**United Utilities Water Limited
Developer Services & Metering**
2nd Floor, Grasmere House
Lingley Mere Business Park
Lingley Green Avenue
Warrington
WA5 3LP

Your ref: 3/2018/0914
Our ref: DC/18/4460
Date: 08-NOV-18

Location : Land off Clitheroe Road Whalley (Lawsonsteads phase 2) BB7 9RG
Proposal : Erection of 188 new dwellings including means of access and associated works

Below Ground Drainage Layout
Sheet 2

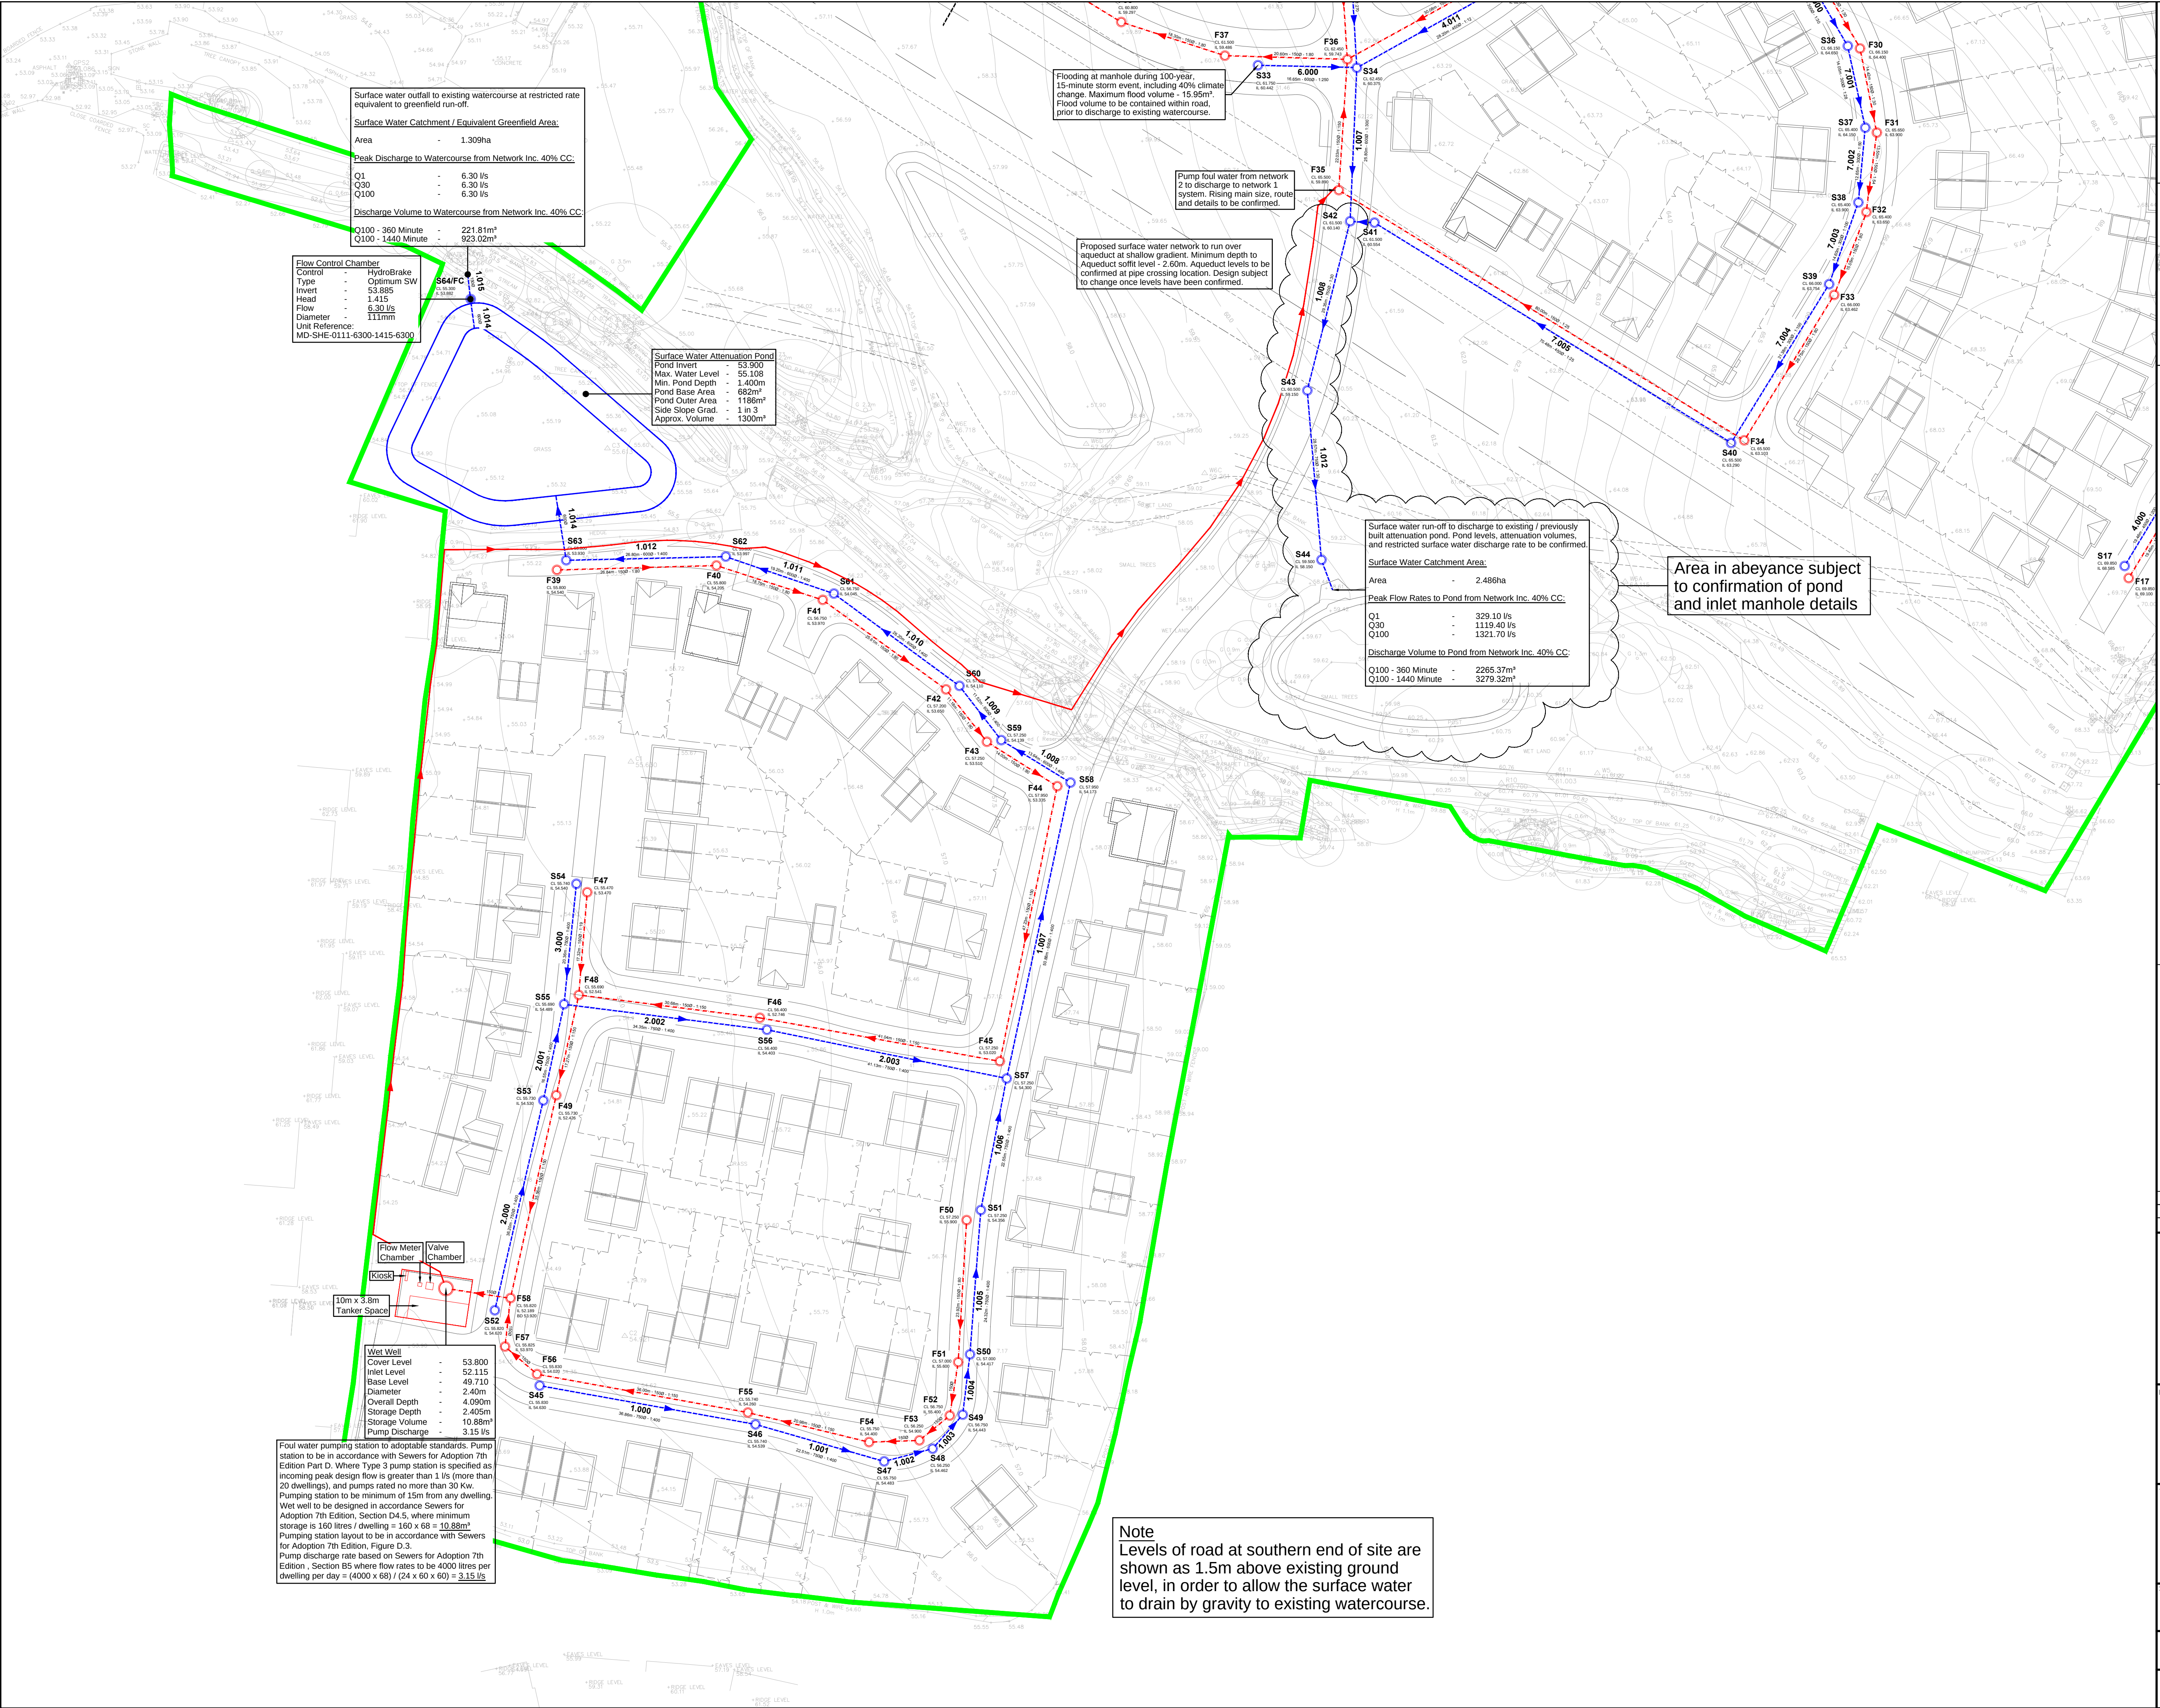
Further to our review of the 'Proposed Unit Mix Plan (Roof Plan) AA7403 2010 REV A, dated Sep 2018 and 'Below Ground Drainage Layout Sheet 2' Project Number 1040-01, Drawing Number D0102 Revision P2, it appears that the proposed ponds may be located in close proximity to the water pipelines and both foul and surface water drainage pipes constructed above the pipelines.

The drainage for the development hereby approved, shall be carried out in accordance with principles set out in the submitted Foul & Surface Water Drainage Design Drawing D0102, Rev P2 - Dated Aug 18 which was prepared by Civic Engineers. For the avoidance of doubt no surface water will be permitted to drain directly or indirectly into the public sewer. The development shall be completed in accordance with the approved details.

Whilst the principle strategy set out by the applicant is in line with United Utilities requirements, we suggest the applicant considers the location of the proposed rising main. We suggest the rising main should be located within the proposed carriageway rather than through residential rear gardens because this will have an effect on the future adoptability of the scheme.

Should the council be minded to grant permission for this scheme, given the significant strategic importance of the water pipelines at this location, it is critical the detail of this scheme is agreed prior to any commencement of work on site.

No construction shall commence until details of the means of ensuring the water mains that are laid within the site boundary are protected from damage as a result of the development have been submitted to and approved by the Local Planning Authority in writing. The details shall outline the potential impacts on the water mains from construction activities and the impacts post completion of the development on the water mains infrastructure that crosses the site and identify mitigation measures to protect and prevent any damage to the water mains. Any mitigation measures shall be implemented in full in accordance with the approved details.
